From: Kirstin Oldfield <[REDACTED]>
Sent: 28 November 2017 17:26
To: Amber Willard
Subject: Re: A-183-17-T

'Crown reduction of 2-3m to No1. Horse Chestnut tree'

PROPOSAL TO FELL TREE ON
PRIVATE LAND FRONTING NO 1 AND HAMBROOK HOUSE
WEST DRIVE, ANGMERING BN16 4JE

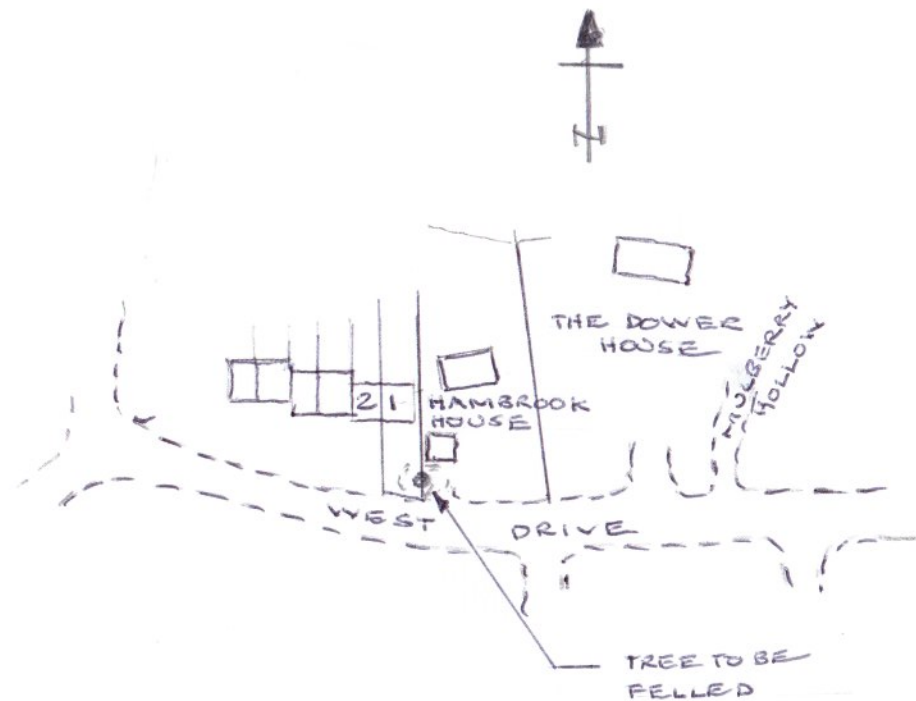
Yes that's fine can it also say to remove any dead wood and overhanging branches over garage and road.
Many thanks.
Kirstin

I have been contacted by Richard Martin who states that a ' 2-3m Crown reduction would be acceptable works for the tree.

Do you agree to the revised description as follows:
